DECISION DELEGATED TO HEAD OF PLANNING

Application No: H09-0175-22 **Applicant:** Mr & Mrs S Hill
Proposal: Proposed two storey side extension
Location: 5 Huntingdon Close Holbeach Spalding
Terminal Date: 12th April 2022

| REV.                                            | DATE | AMENDMENTS |
|-------------------------------------------------|------|------------|
| 5 / HCH / 201                                   |      |            |

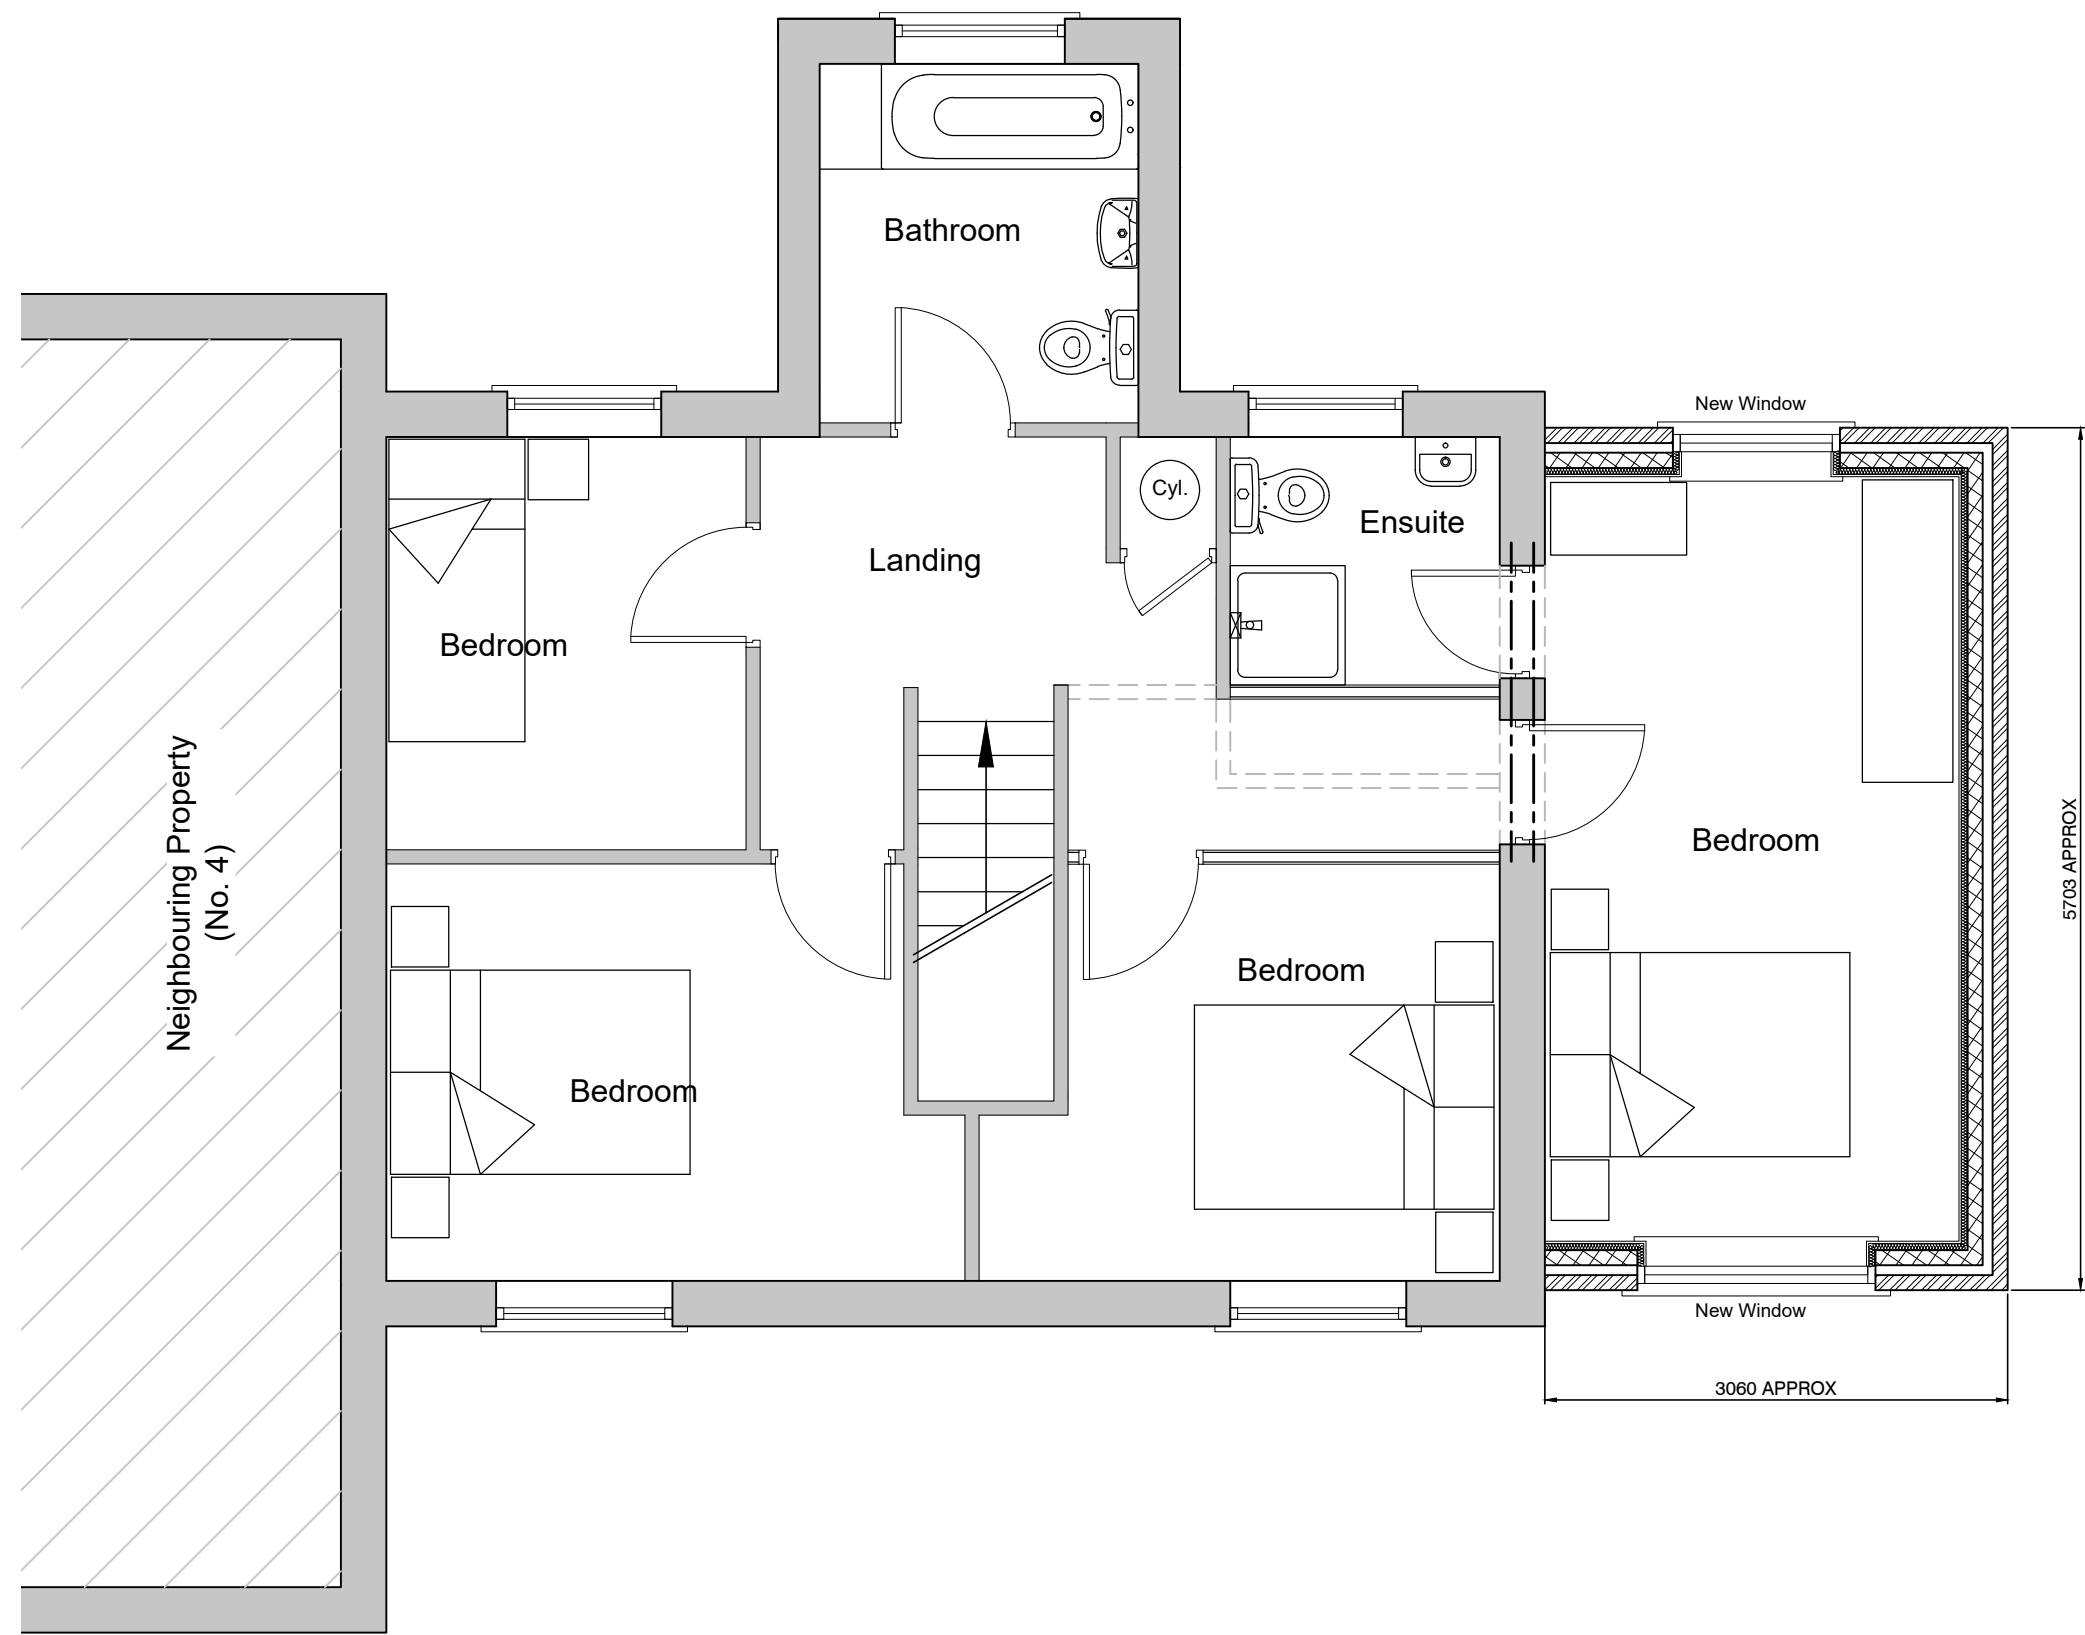
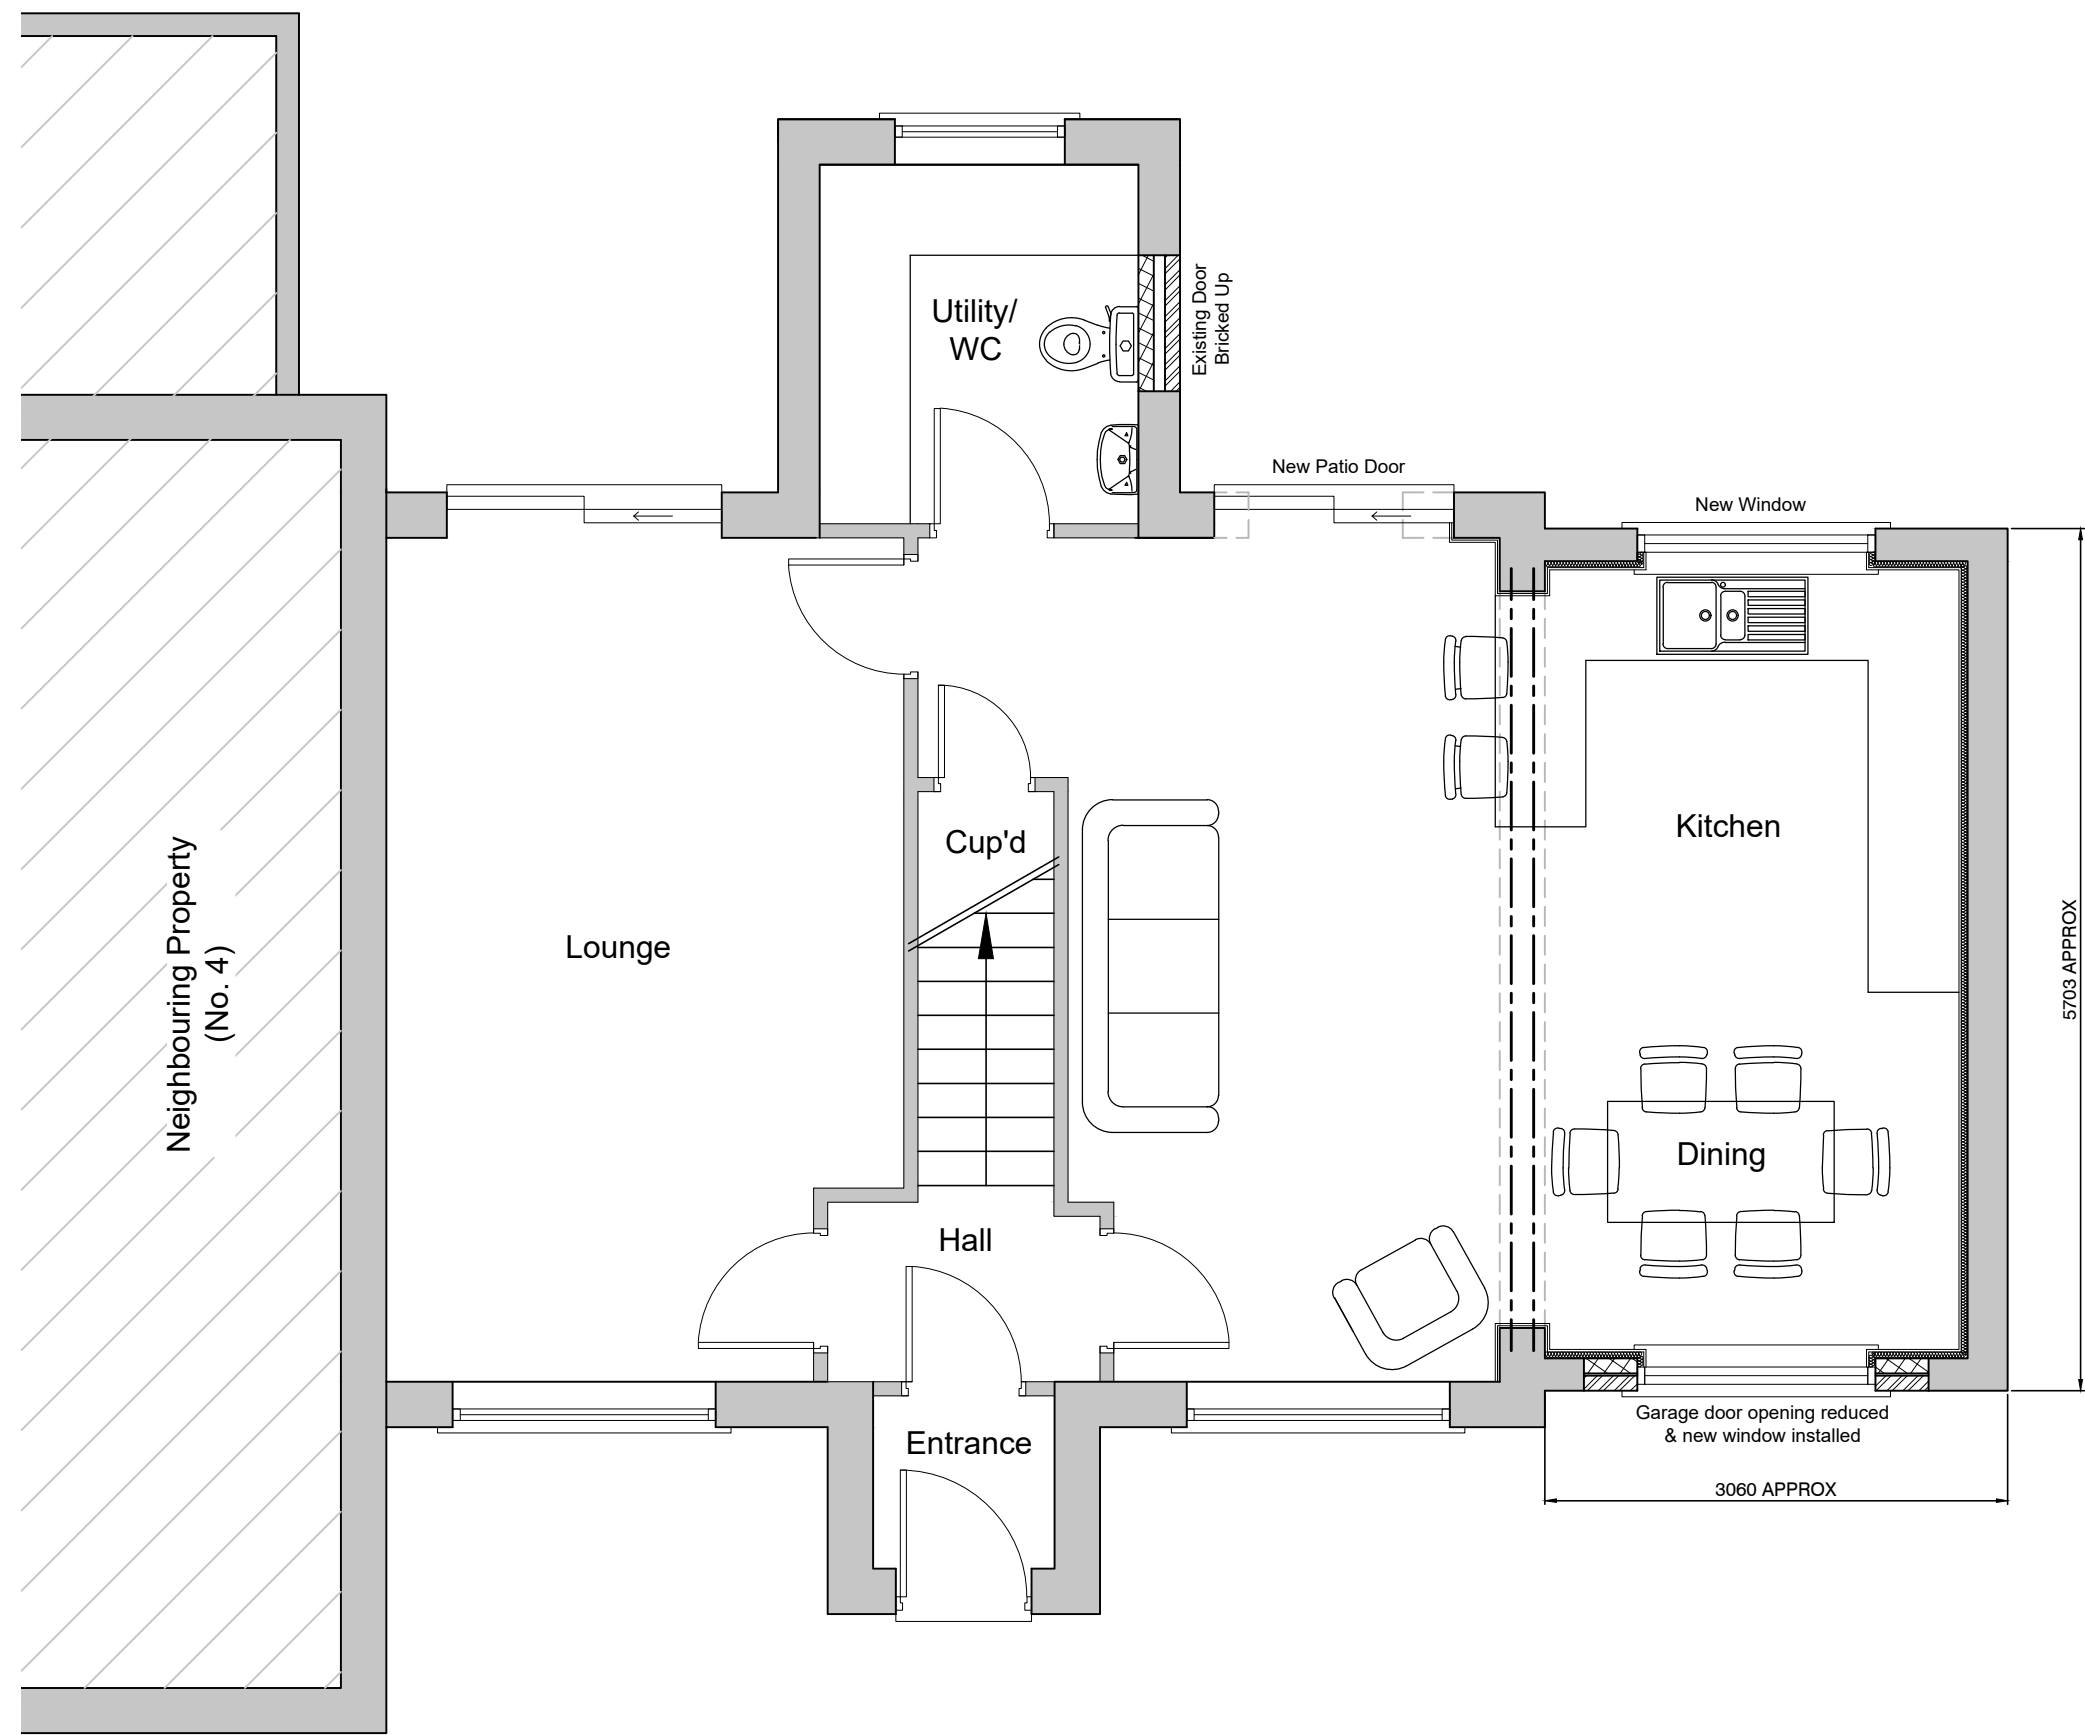
The proposed two storey side extension is considered to be proportionate to the existing dwelling and the plot. Its design with the roof following the shape of the existing roofline would respect the design of the existing dwelling. Although a lowered roof ridge is usually required for side extensions, in this instance a flush finish can be accepted given it would not result in a terracing effect. The extension is not considered to appear unduly incongruous within the rural street scene and would not materially harm the character/appearance of the locality. The extension would not extend beyond the front/rear elevations of the existing dwelling therefore there would be an element of subservience. The proposed use of matching external materials would ensure the extension is in keeping with the existing dwelling.

The closest neighbour is the attached neighbour at no.4 Huntingdon Close. The proposed extension would not be visible to this neighbour as it would not extend beyond the front/rear elevations of the applicants existing two storey dwelling and would therefore be blocked by this. As such no unacceptable impact would result on this neighbour.

The only other immediate neighbour is no.6 Huntingdon Close located to the north-east of the application site. The proposed extension would be sited some 11 metres from this neighbours boundary and approximately 15 metres from its nearest elevation. Given the relationship with this neighbour this separation distance is considered sufficient as to not result in any overbearing impact, overlooking or unacceptable overshadowing.
